**Application for Planning Permission for Works or
Extension to a Dwelling**

DECISION NOTICE

Application Ref: LU/31/15/HH

First floor rear extension. This application may be determined by Littlehampton Town Council under delegated powers.

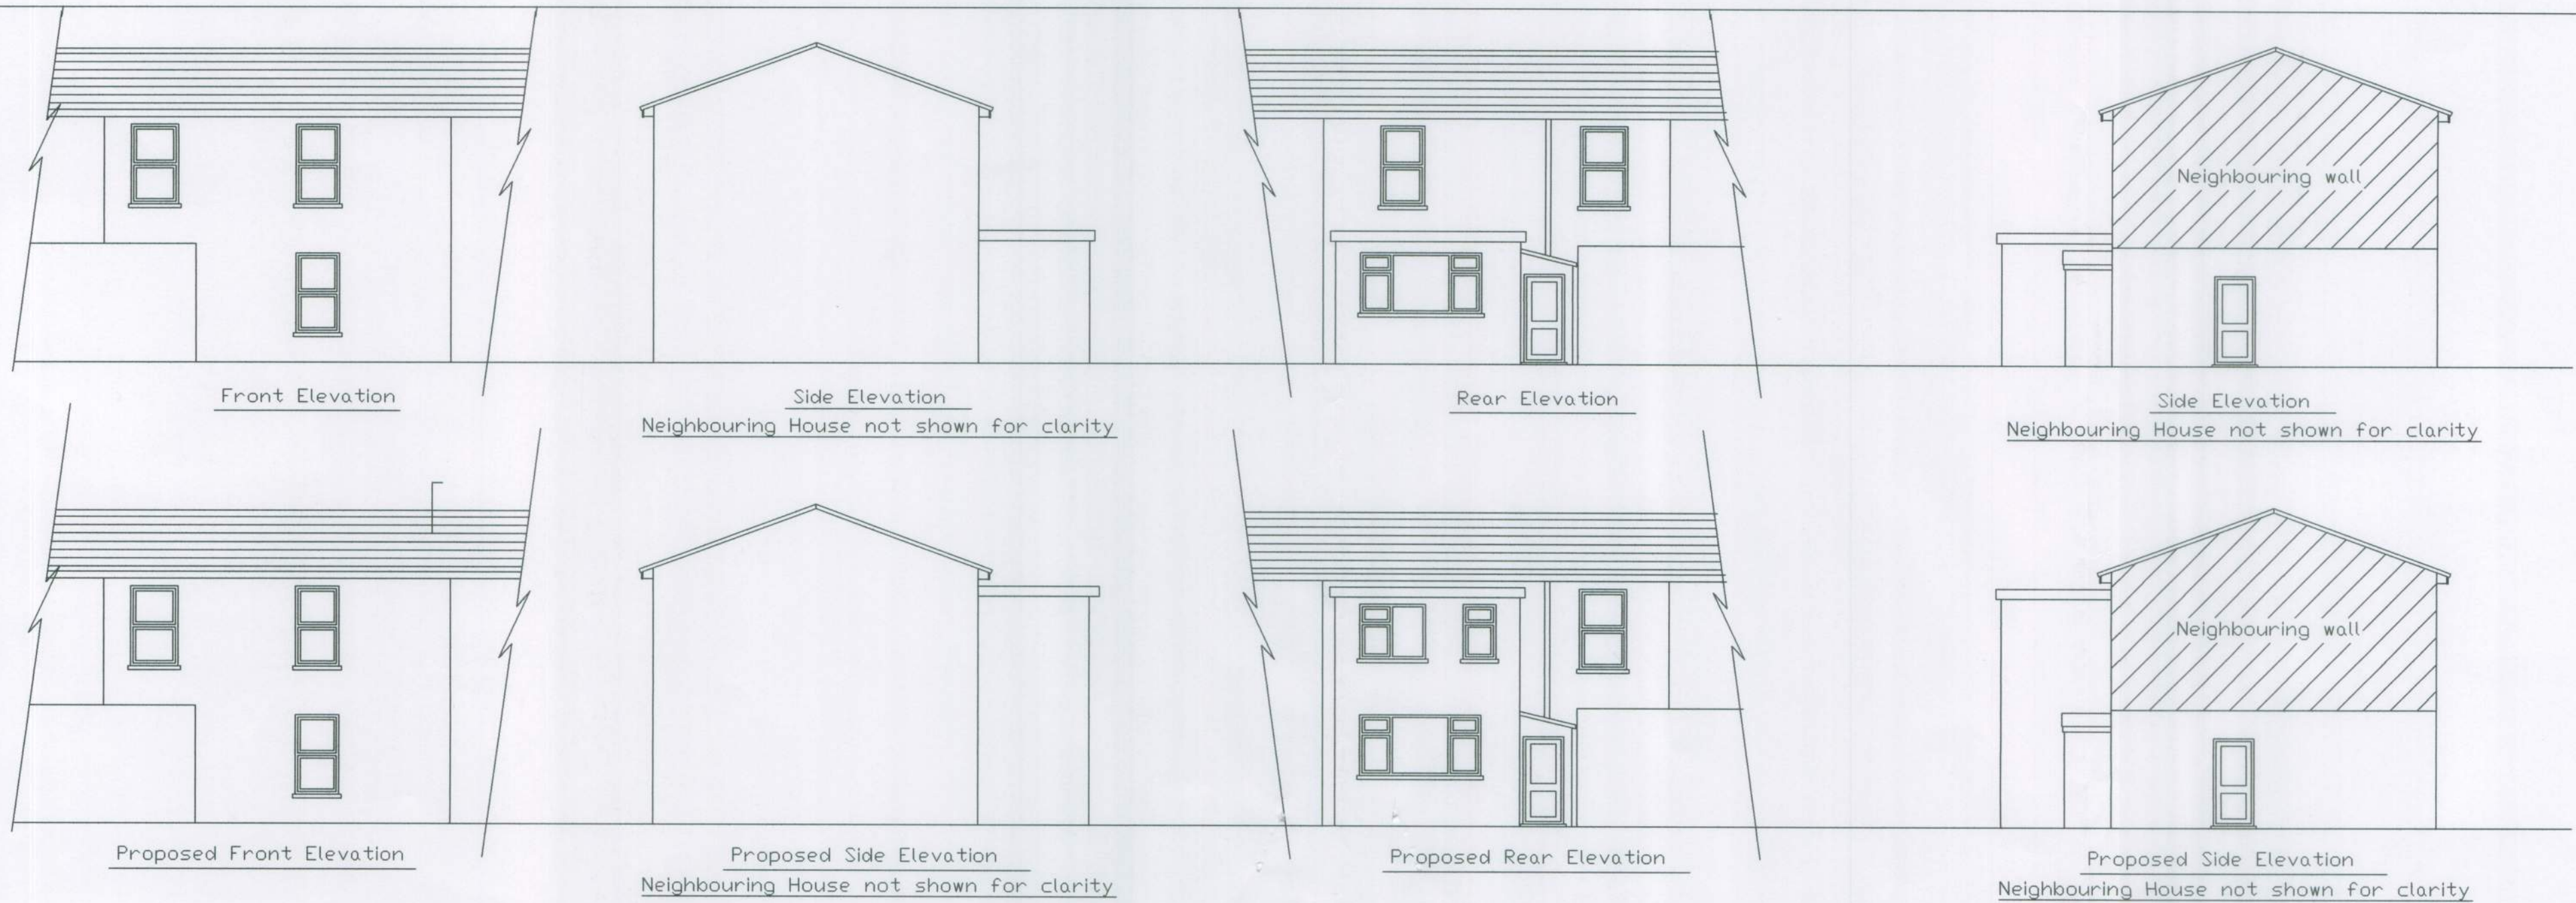
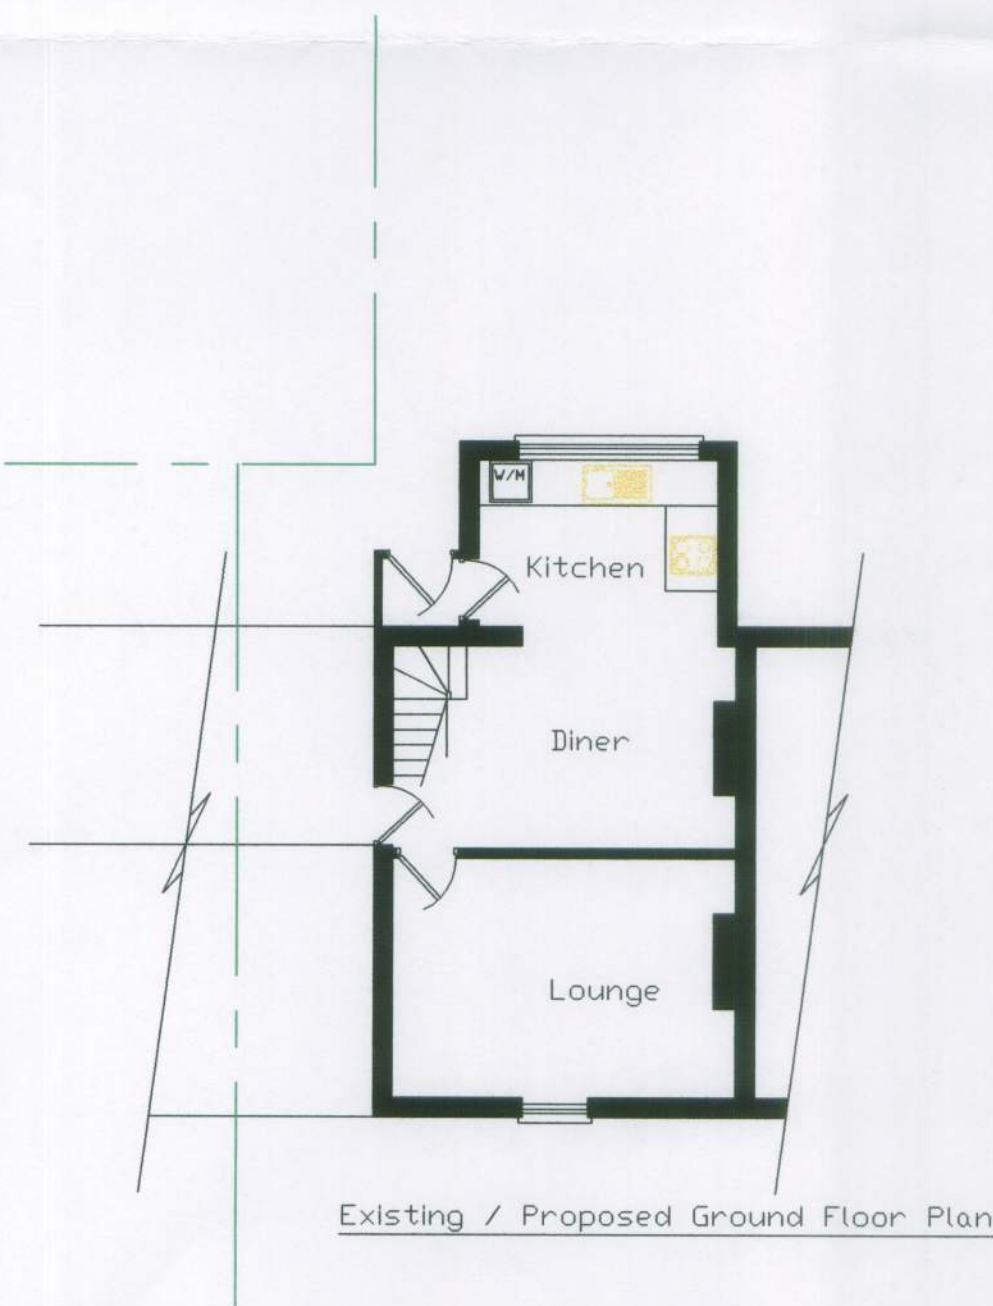
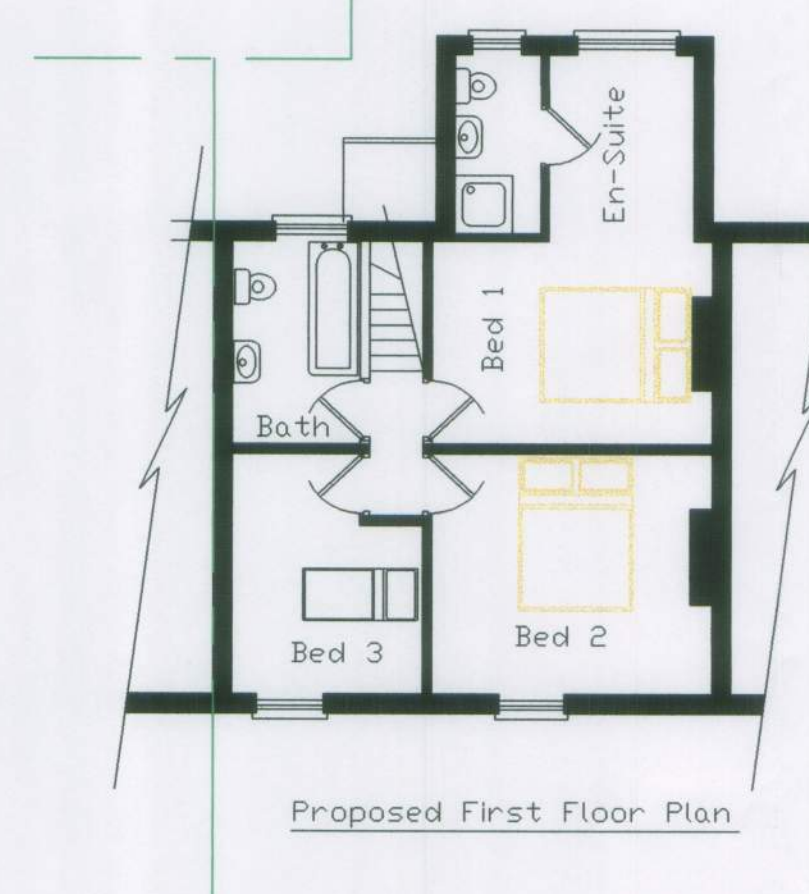
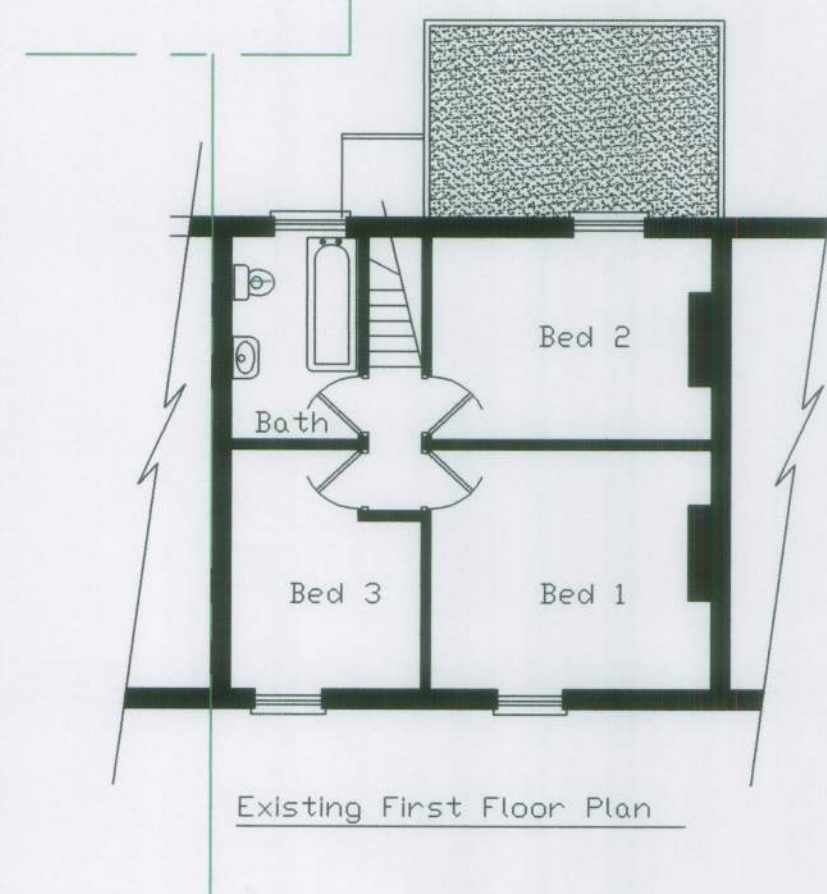
- 1 Having regard to the height of the extension and its proximity to the western boundary the proposal would give rise to an unneighbourly form of development which would be prejudicial to the amenities and environment of 18 North Street in conflict with policies GEN7 and DEV19 of the Arun District Local Plan and policies DDM1 and DDM4 of the Emerging Local Plan and the National Planning Policy Framework.
